Application Reference: 2026/0281

Site Address: 14 Warner Avenue, Pogmoor, Barnsley, S75 2EQ

Proposal: Erection of a single storey flat roof storage outbuilding to the rear of the garden.

A Elevation A- Front
1:50

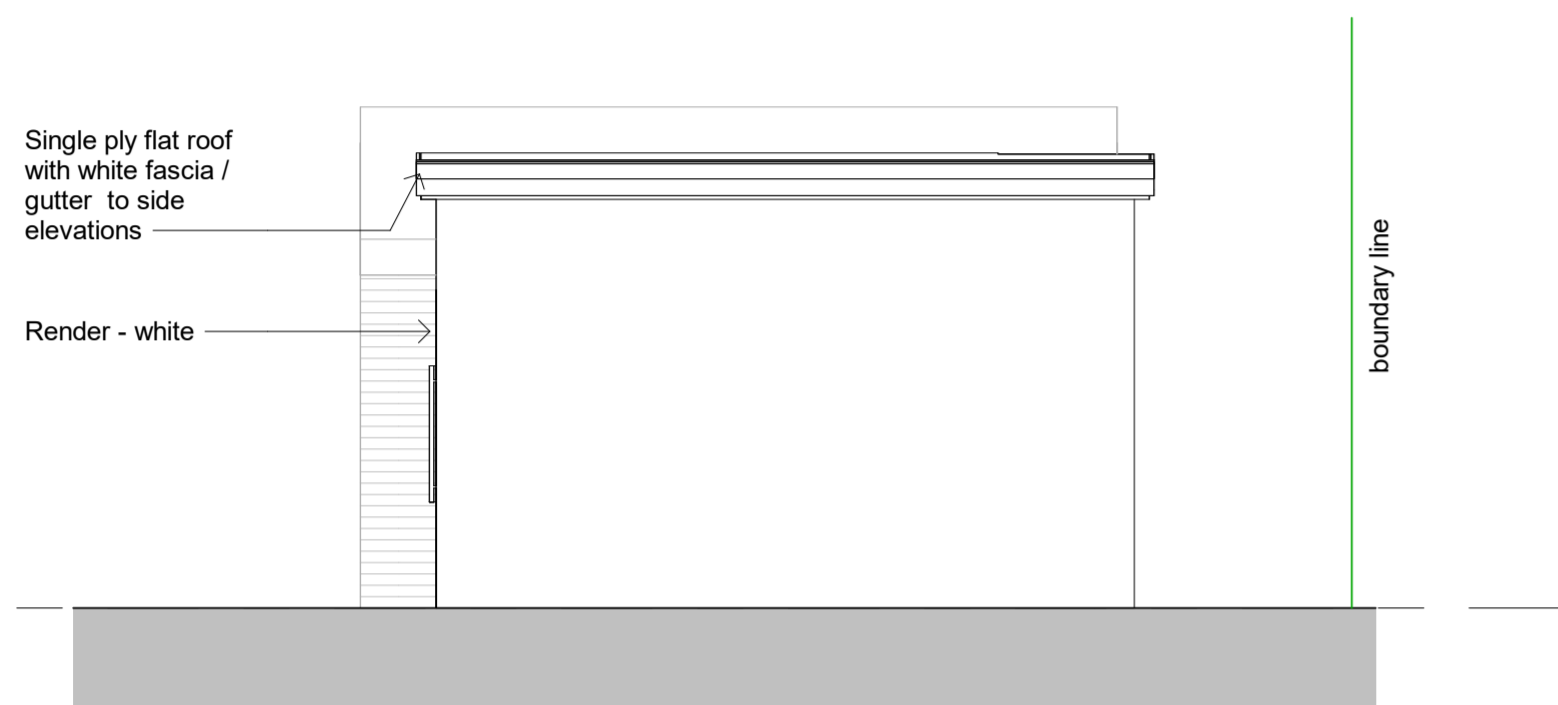
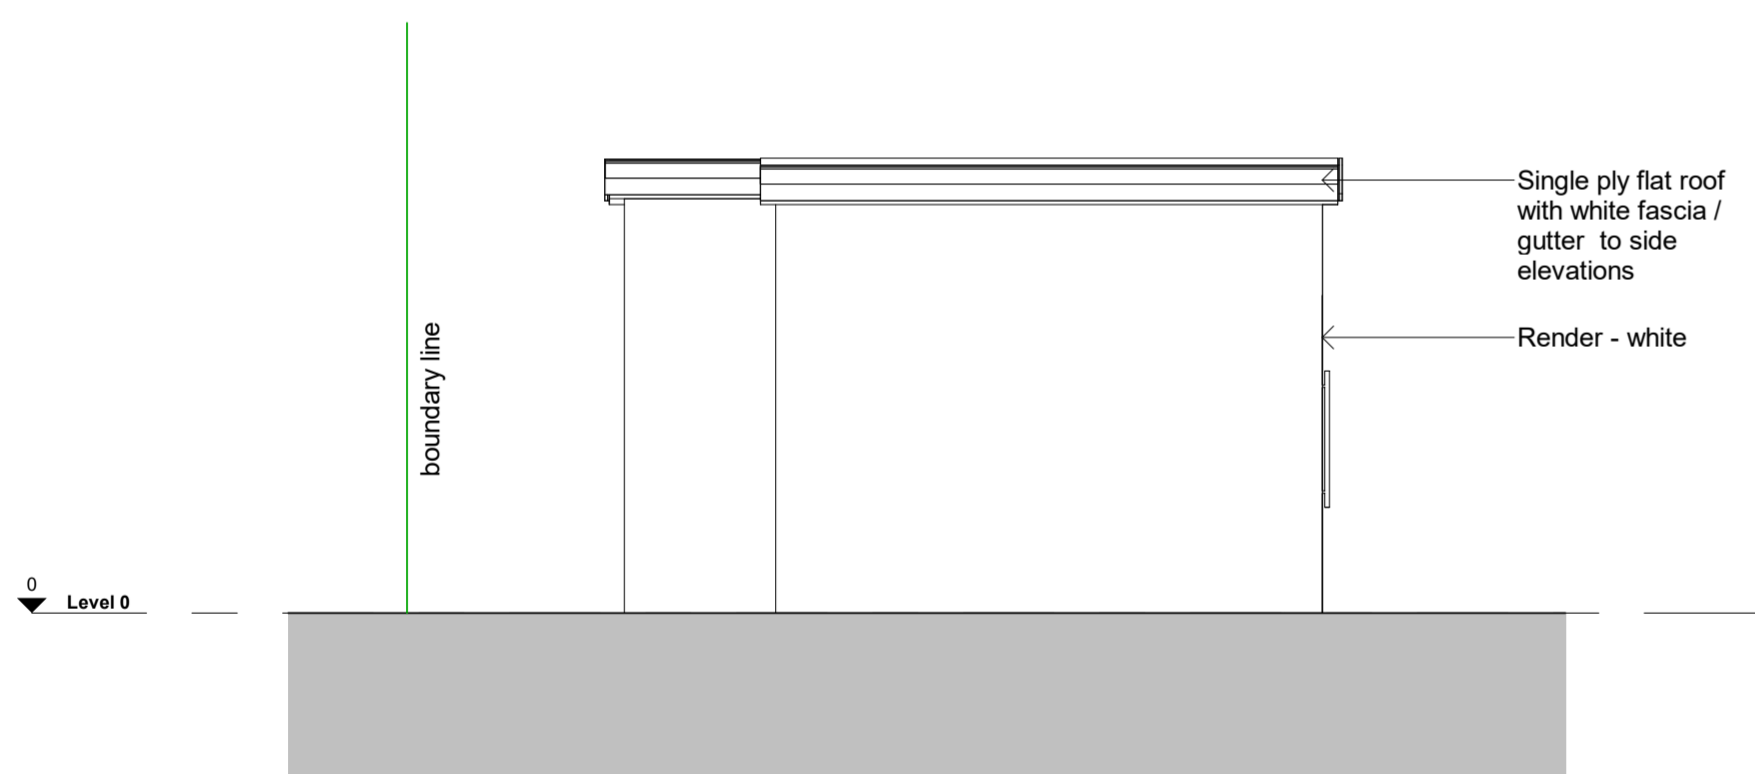
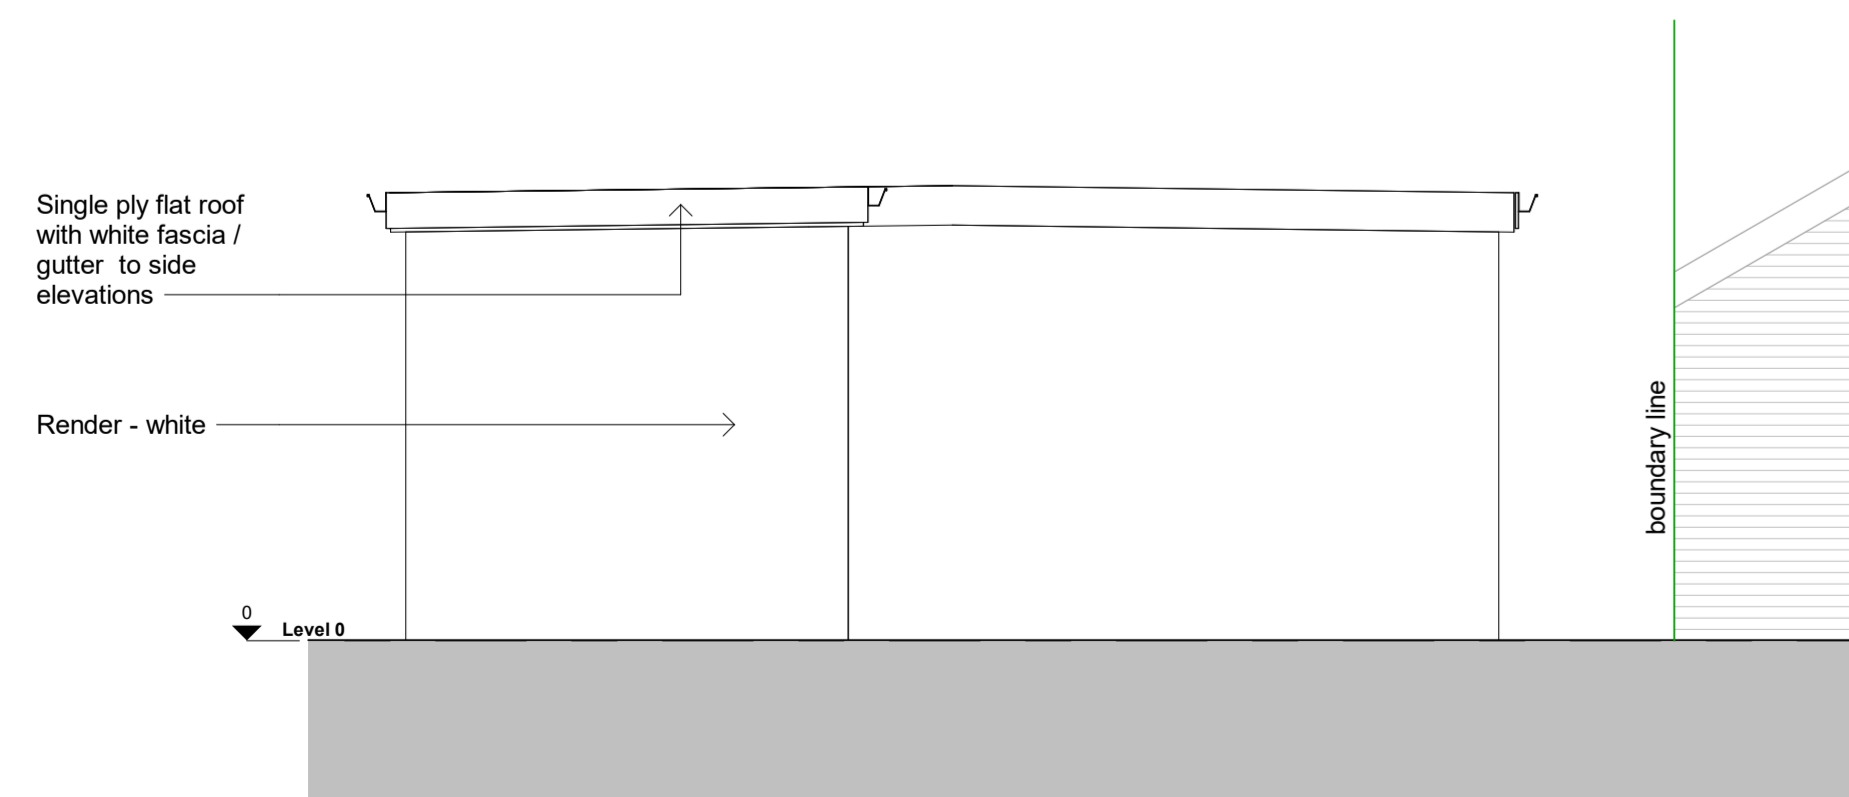
The proposed outbuilding details a flat roof, which is acknowledged to not match the site dwelling, however, the flat roof would provide a less dominant proposal and cannot be seen within the street scene. As such the flat roof would not be impactful on the character of the dwelling or street scene and is considered acceptable. The proposed height of the outbuilding is not considered to be overly dominant on the site and would be lower than the outbuildings to the south and north of the site. A modest floorspace of 23.17 square metres is proposed which is significantly less than the maximum 39 square metres usually permitted. The size and scale of the outbuilding is therefore considered to be modest and appropriate for the site.

Both the doors and windows detailed to the front elevation of the proposal are modest and not considered to be a controversial element of the outbuilding as to raise any concerns. The use of white render proposed to the rear and side elevations is not preferred; however, this would not be seen within the street scene. The use of matching brickwork to the front elevation is welcomed and allows the proposal to remain in keeping with the character of the site.

3. The external materials to the front elevation of the outbuilding shall match those used in the existing building.

The outbuilding would be to the east of 18 Porter Avenue. Any loss of light would therefore be restricted to mostly early mornings. The existing boundary treatment would screen the majority of the proposal, reducing its dominance. No rear windows are proposed, preventing any opportunity for overlooking.

2 Site Plan
1:200

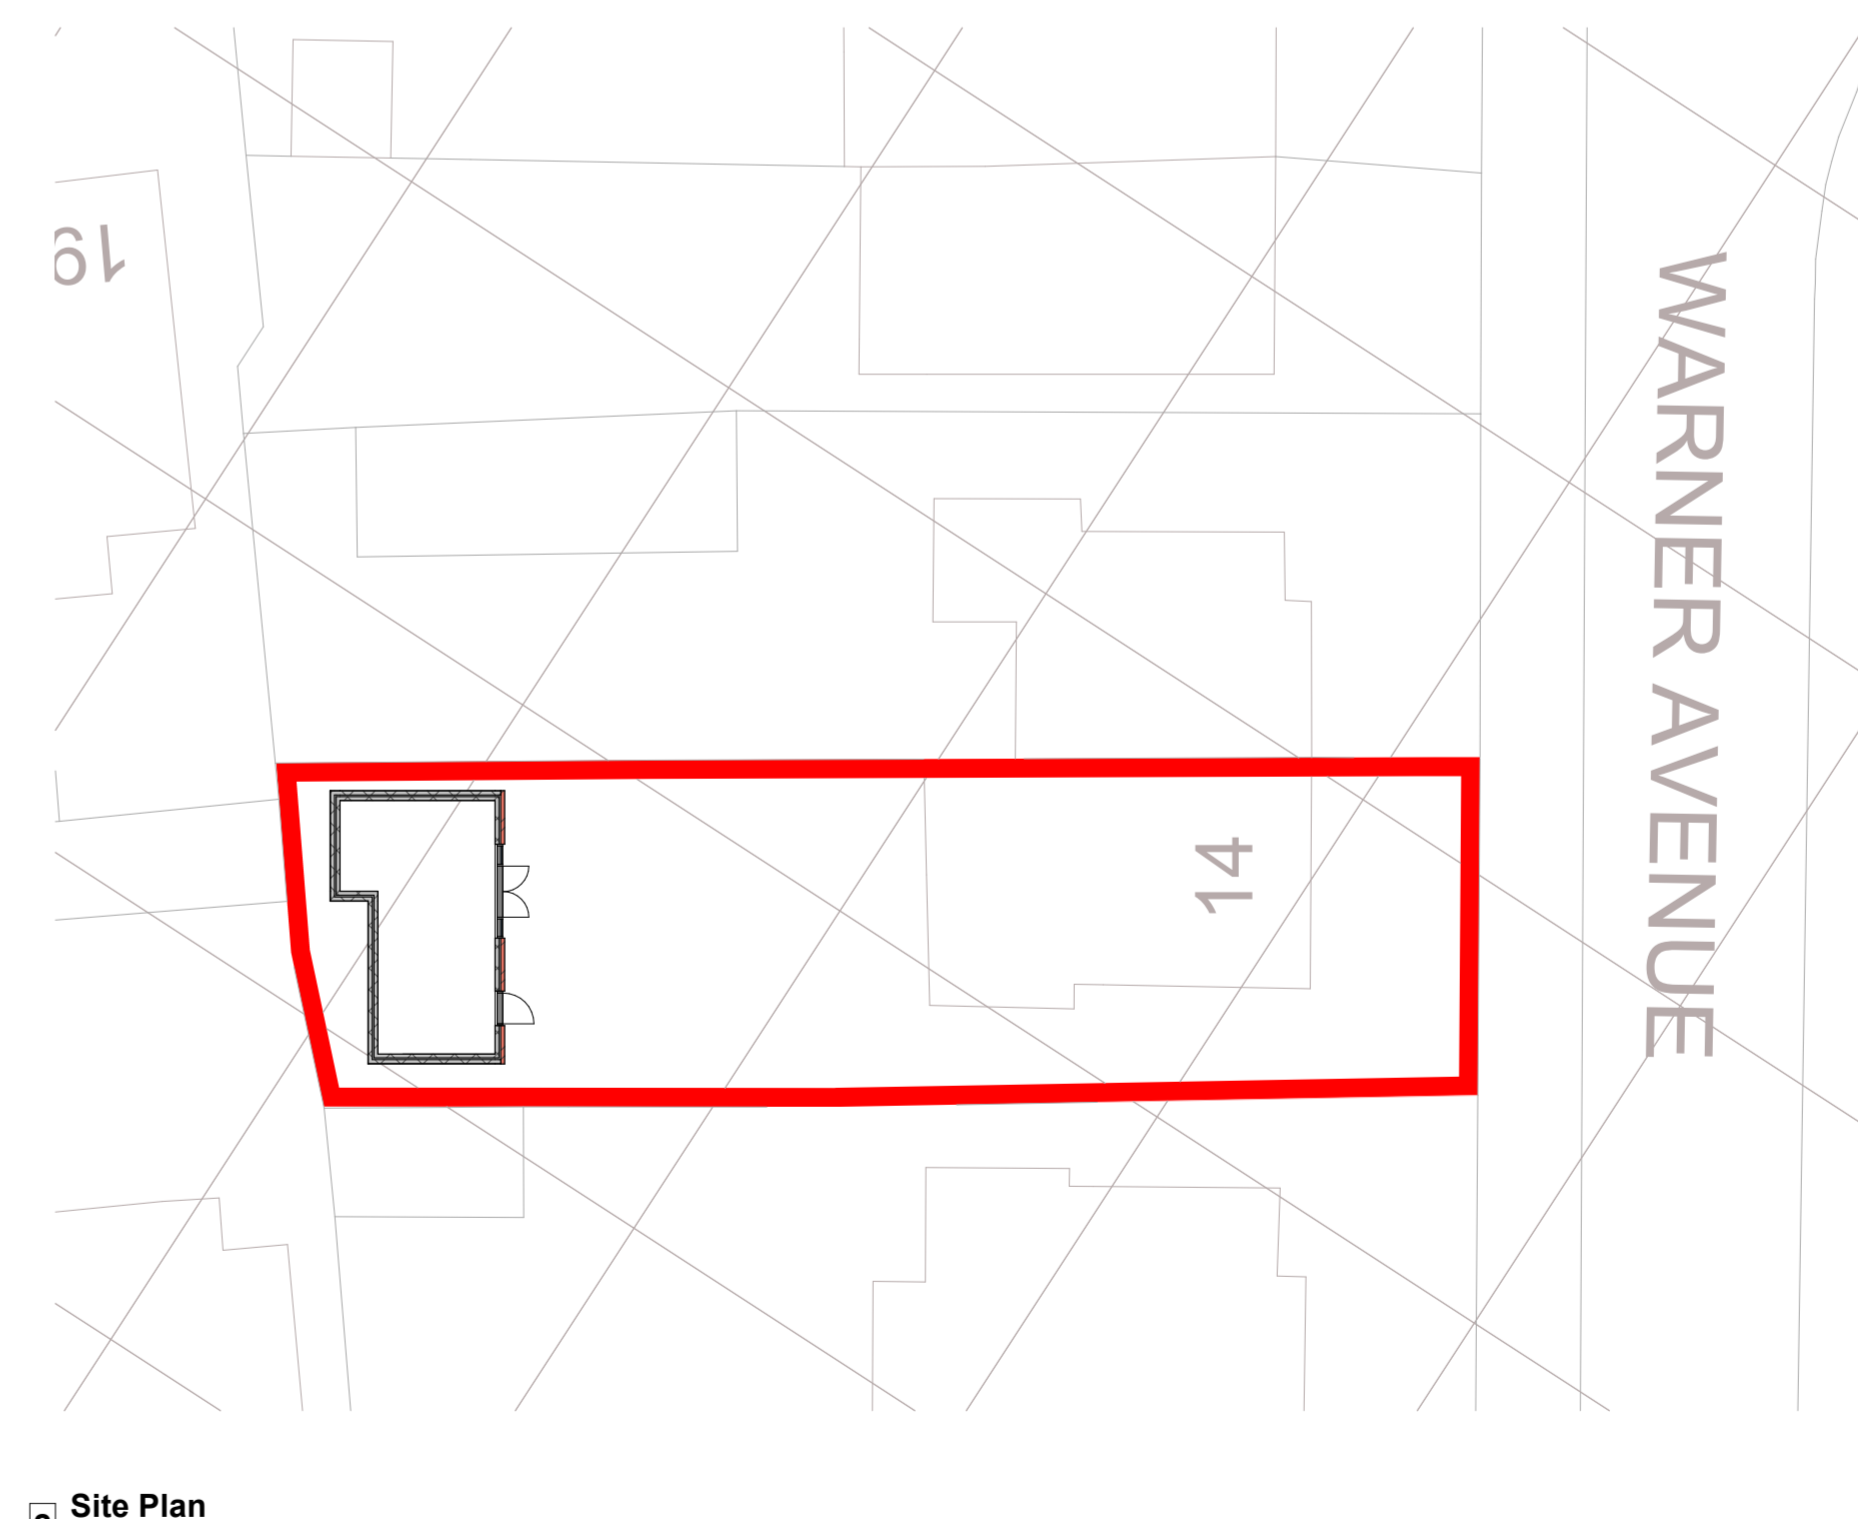
The proposed outbuilding would be located to the rear of the site, at the furthest possible distance away from neighbouring properties. The outbuilding provides a modest roof height which is less than neighbouring outbuildings. The outbuilding is acknowledged to be to the south of 16 Warner Avenue so some overshadowing may be caused. However, any overshadowing would be minimal and to the rear garden space of the northern neighbouring garden space which is already significantly screened by trees and boundary treatment. Additionally, the significant boundary treatment in place would screen the majority of the proposal, reducing the impact of the proposal and preventing any opportunity for overlooking.

The proposal would be to the north of 12 Warner Avenue. Loss of light would therefore not be an issue. The outbuilding would be mostly screened from the south by an existing outbuilding in the neighbouring properties' garden as well as the existing boundary treatment. This also prevents any opportunity for overlooking.
